Responses to July 10, 2020 Preliminary Plan redlines:

Redlines from preliminary plan LOI:

X:\351000\0514200\Drawings\Sheet\Drawings\2514200 Roadway Geometry Plan.dwg - PLOT 7/27/2020 10:04:16 AM - GE

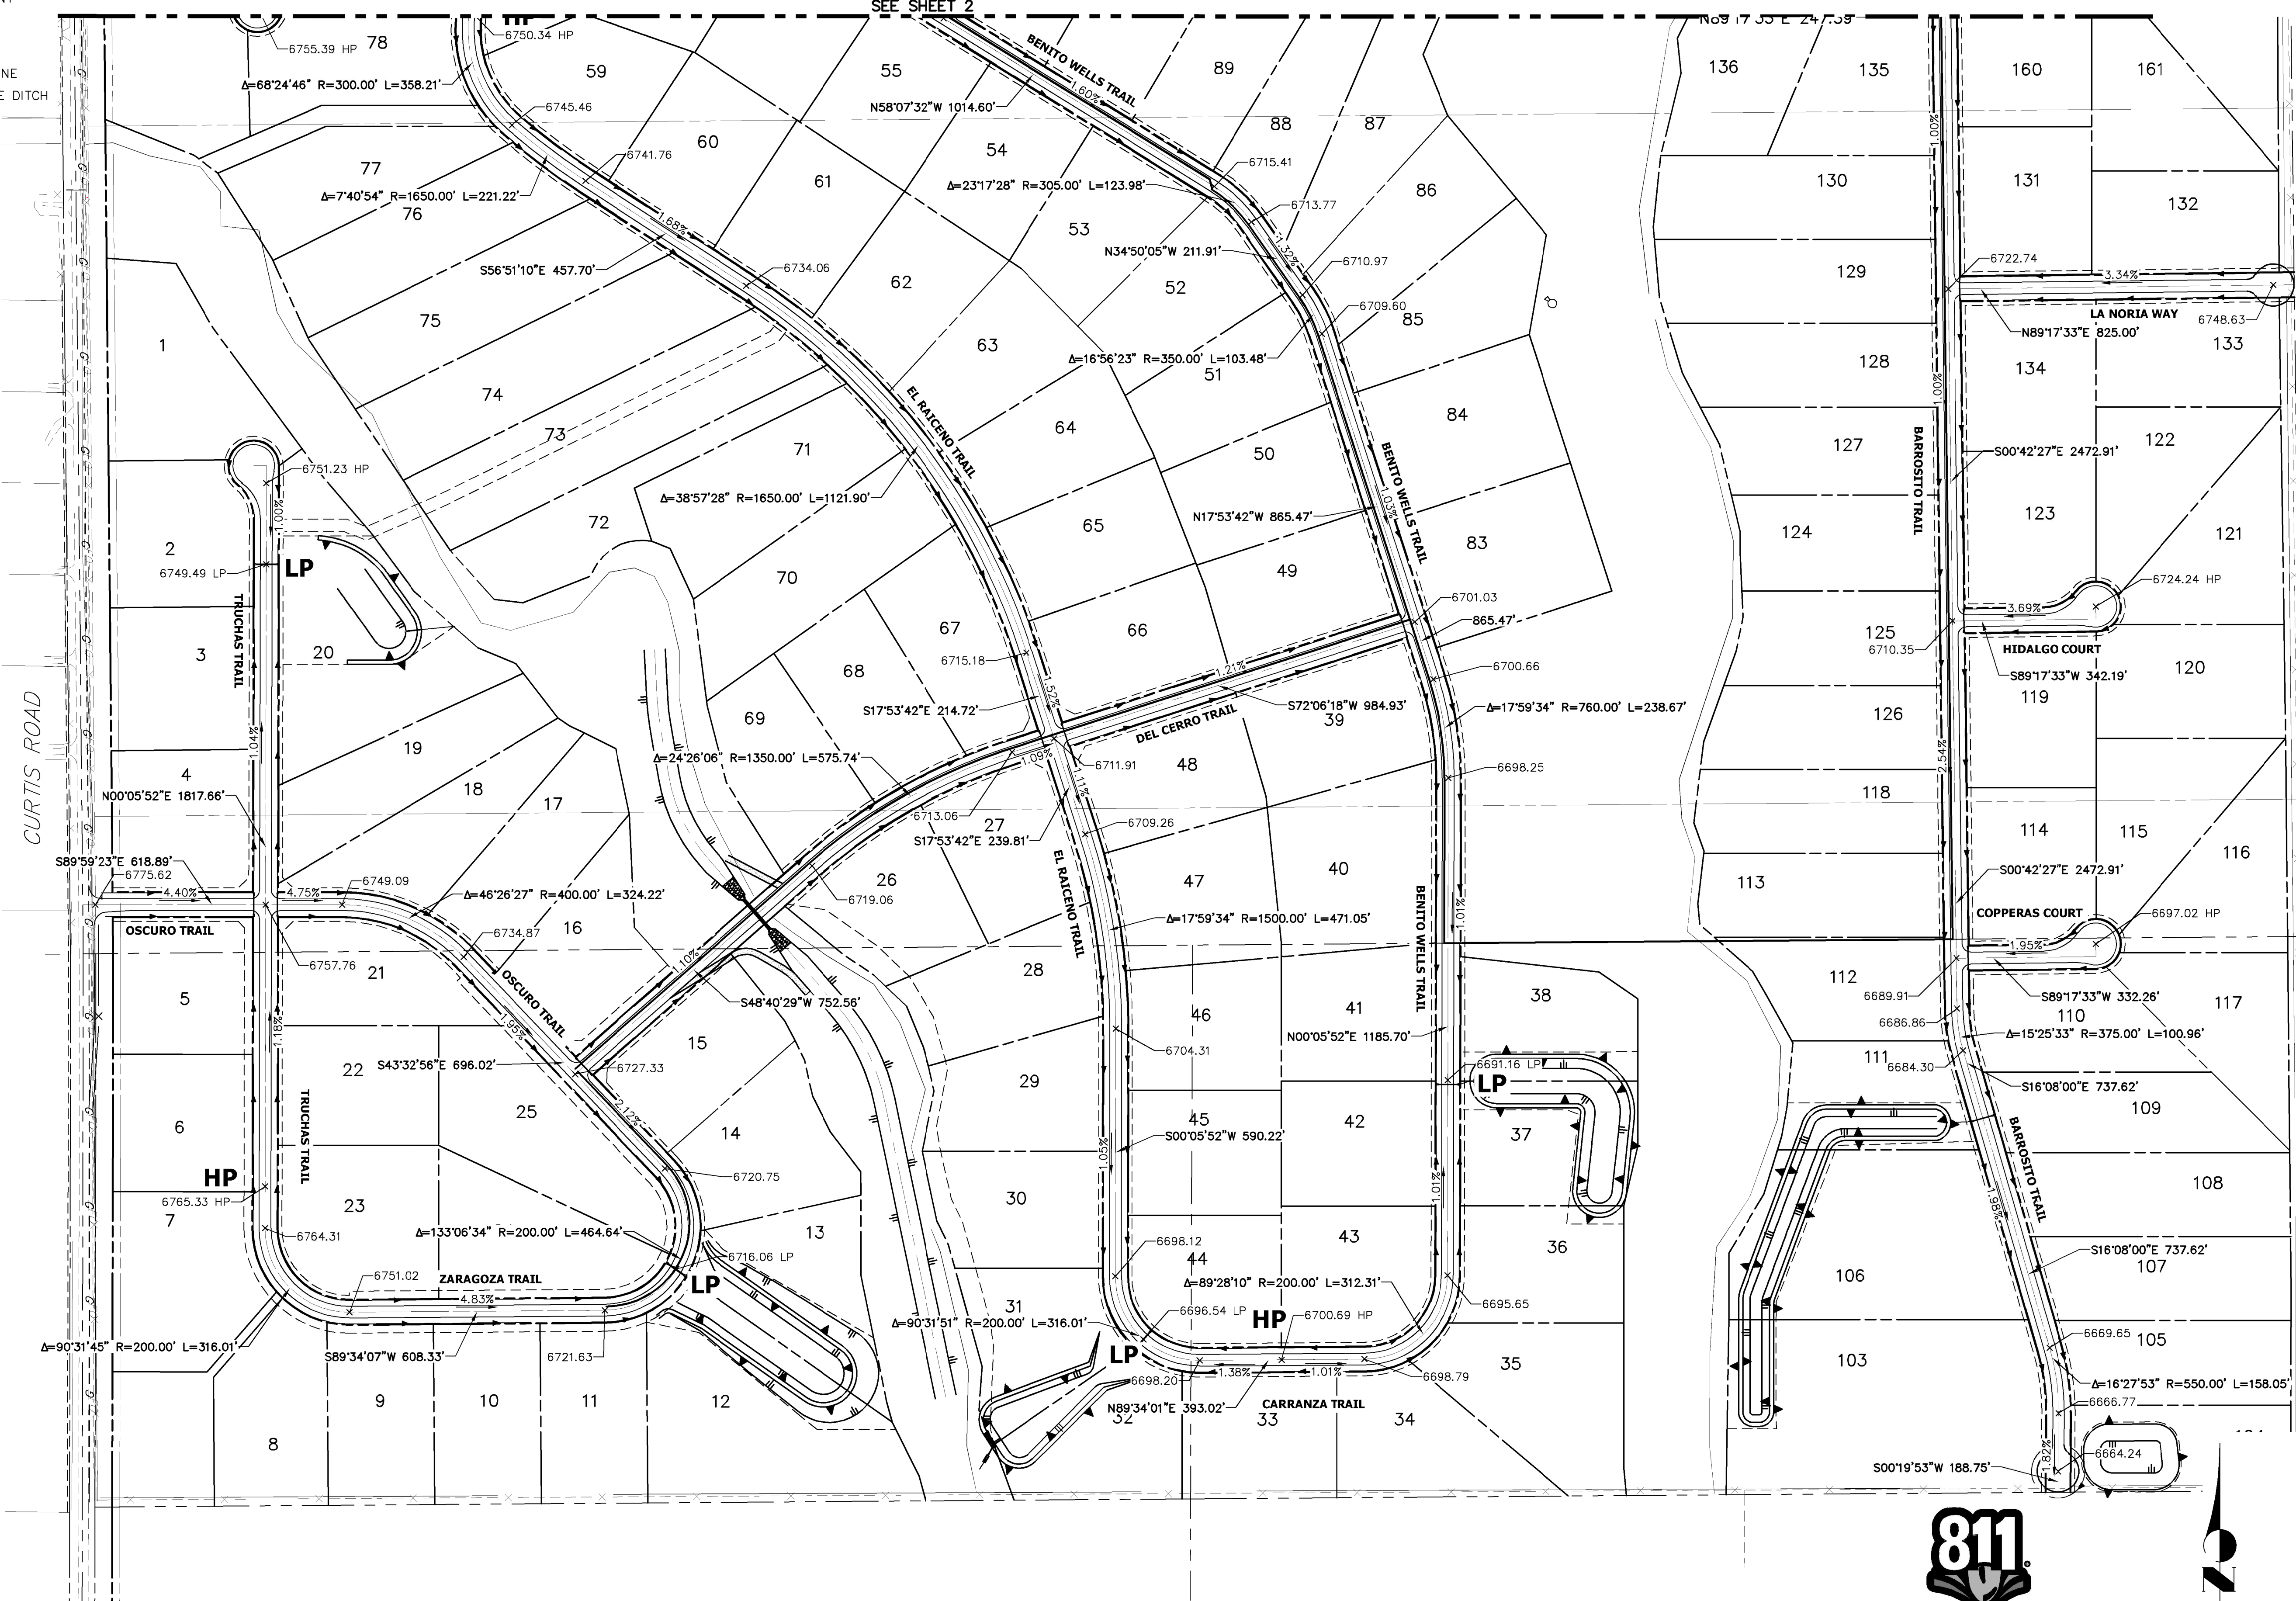
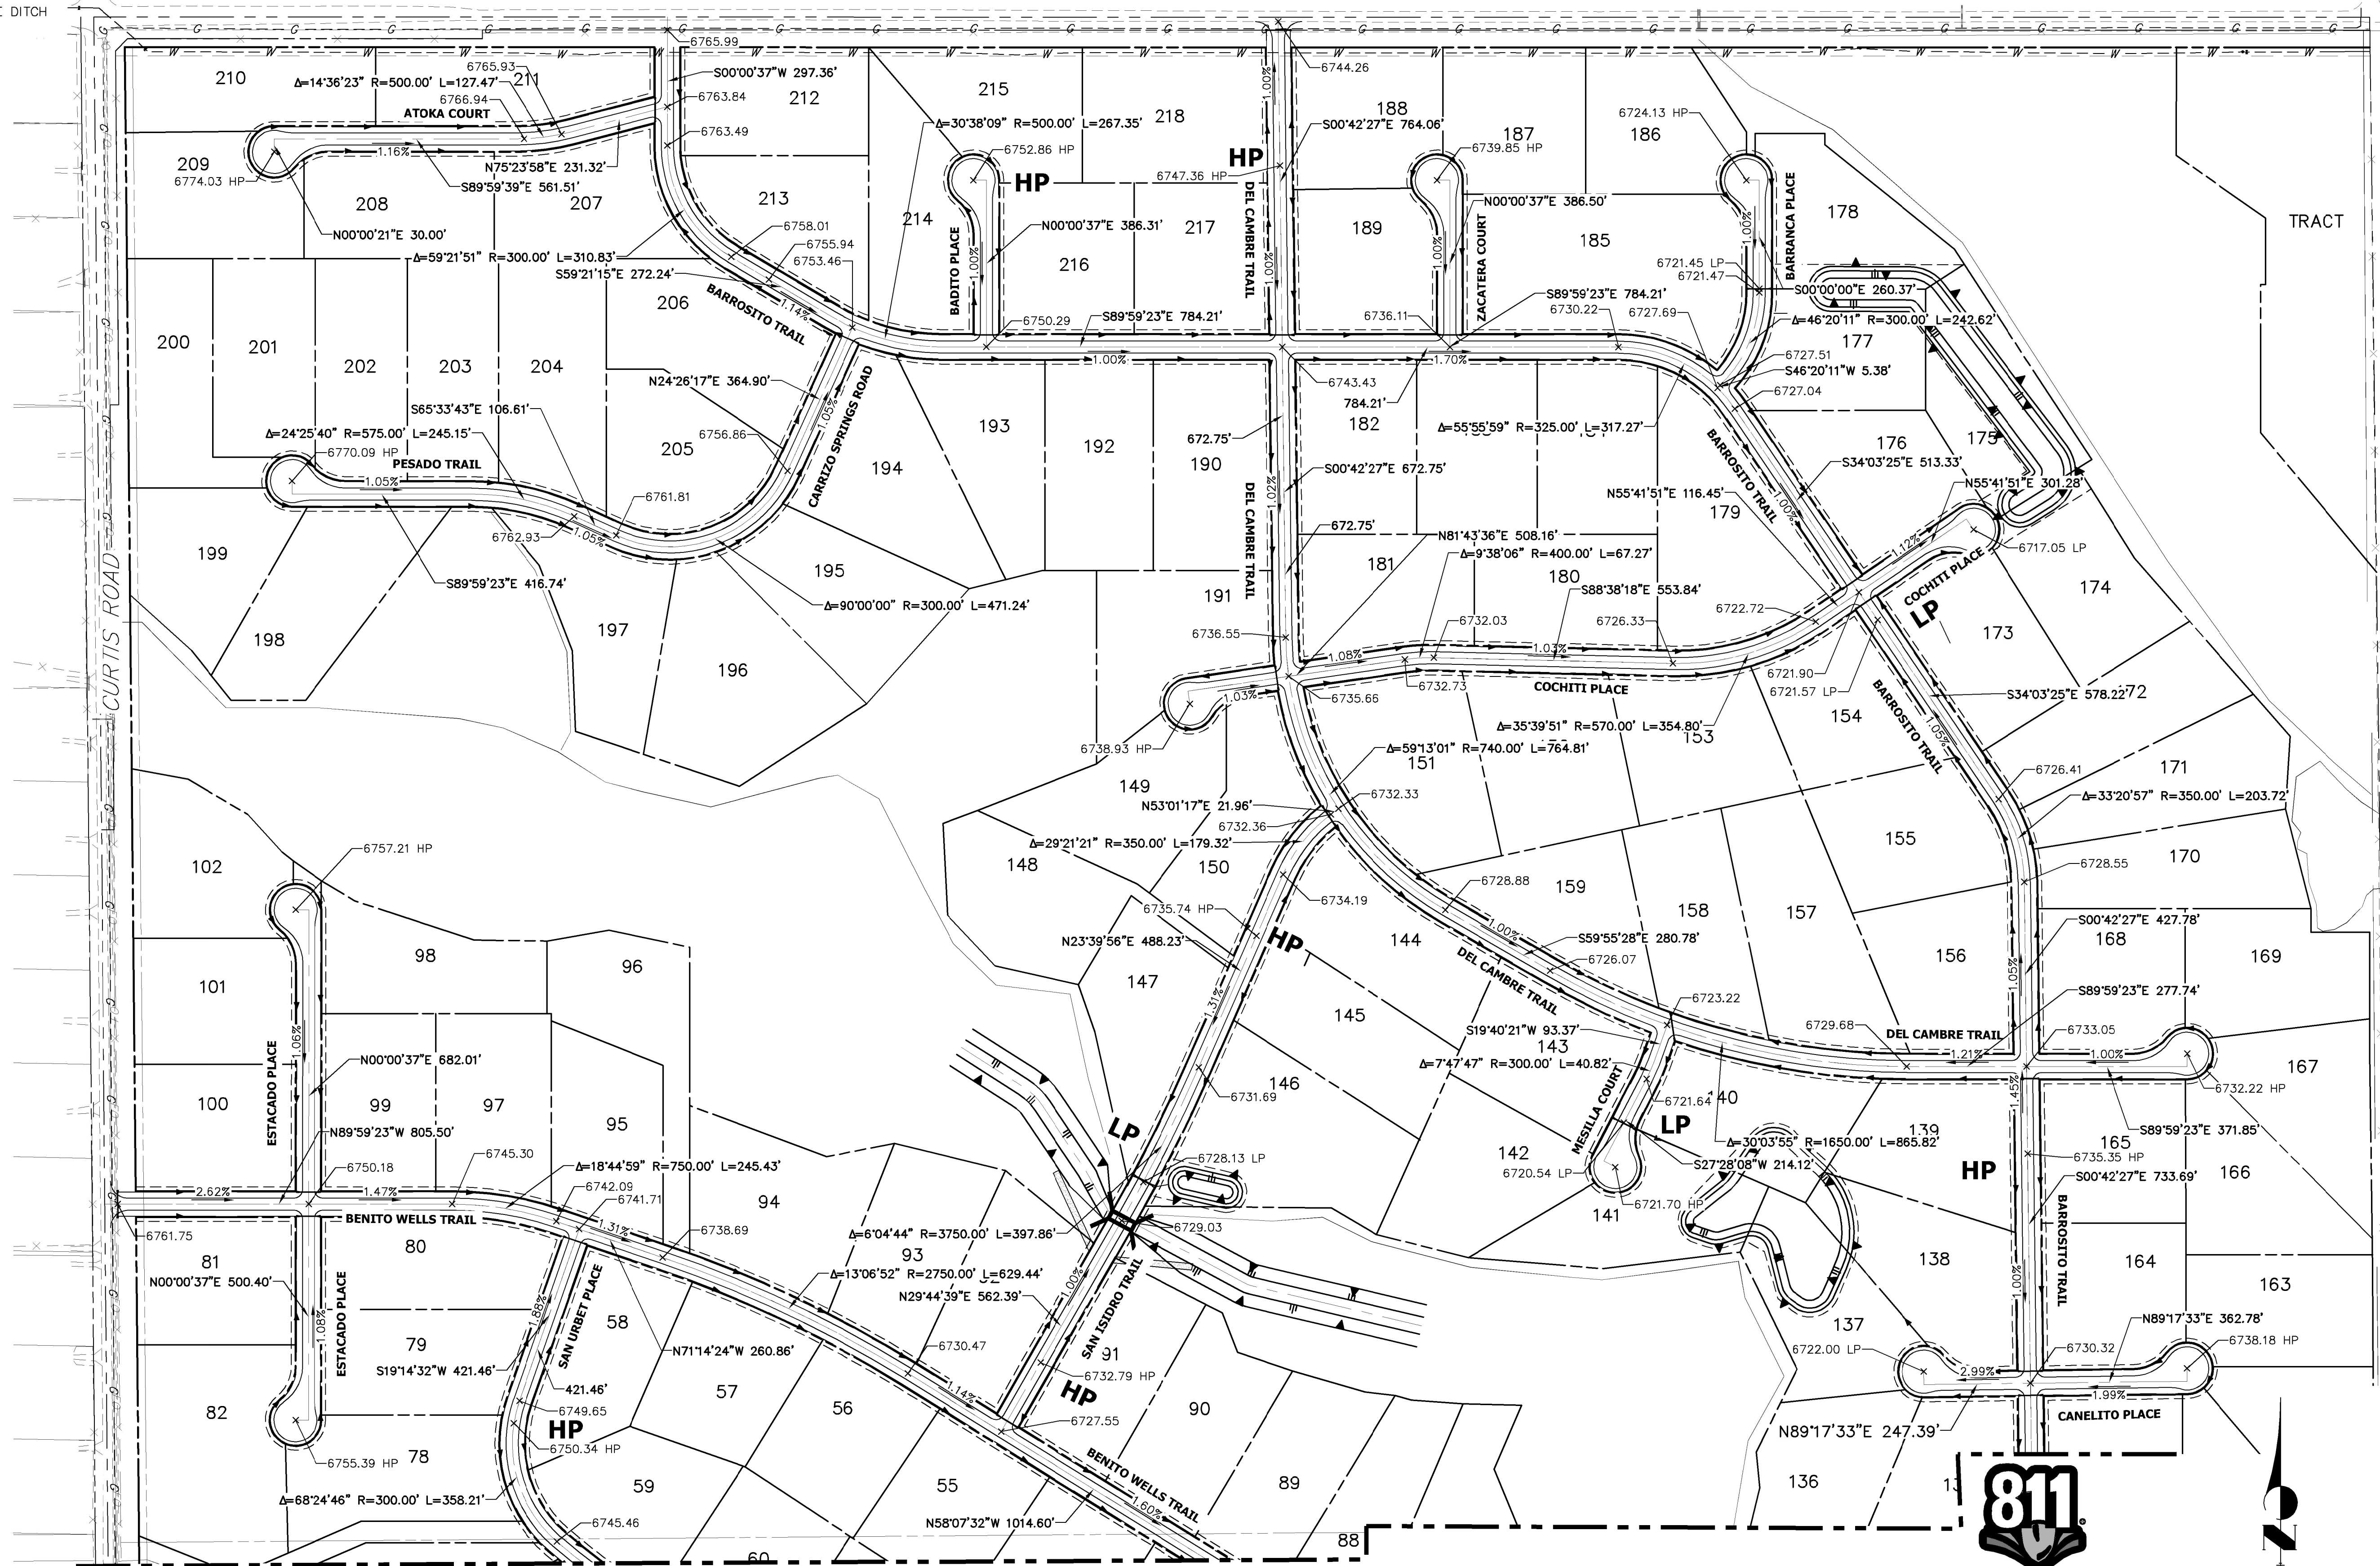
4. On sheet 3, phasing plan (south), County has a single comment. Label all centerlines radii. Guman: No change made to preliminary plan. A separate plan set titled “Roadway Geometry Plan” has been uploaded as an optional item. This plan set shows all centerlines’ radii.
